LOT 24-25 WAREHOUSE BUILDINGS
7358-7386 COLE VIEW, COLORADO SPRINGS, COLORADO 80915

SITE GRADING & EROSION
CONTROL PLAN

TYPICAL GRATED STORM INLET DETAIL (D)
SCALE: NTS

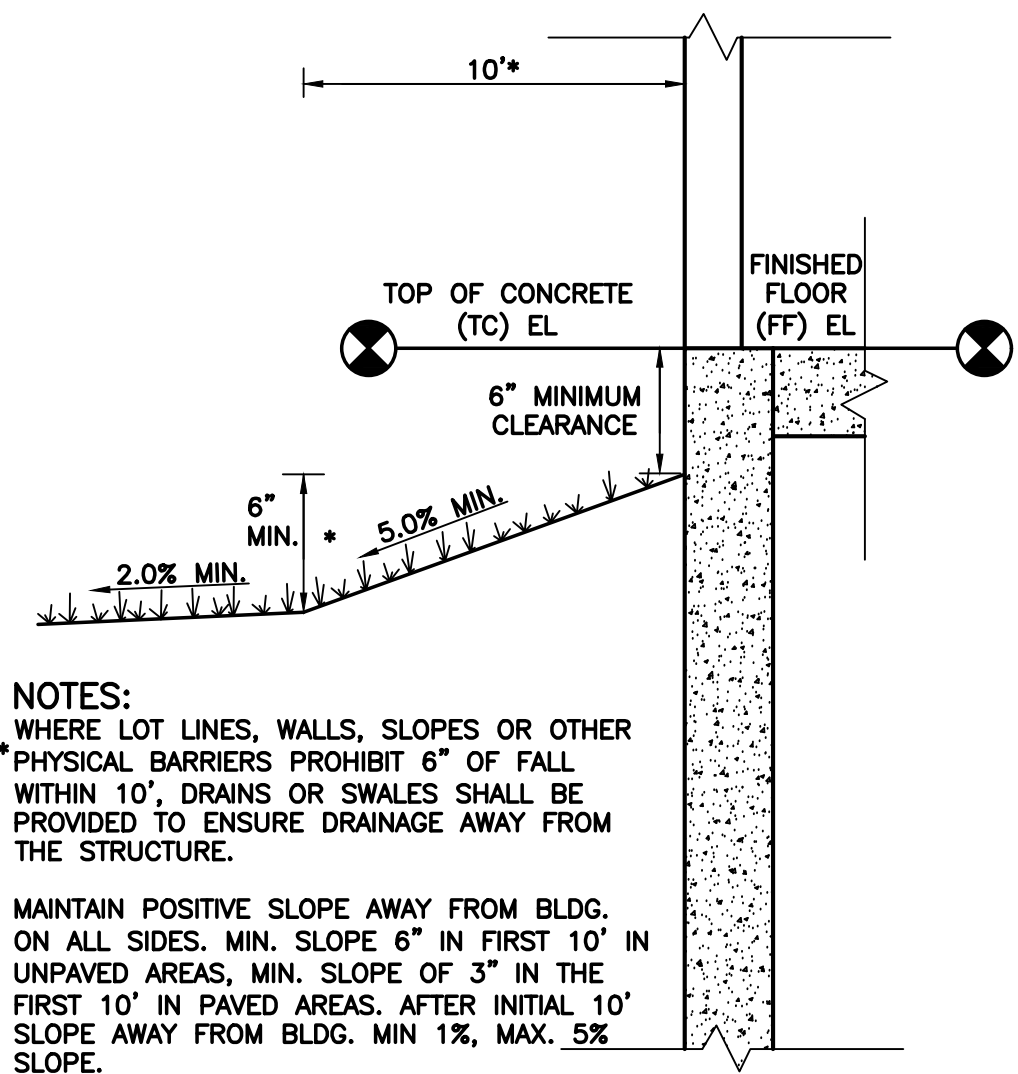
Please provide detail for inlet, inlet protection and call out type of inlet.
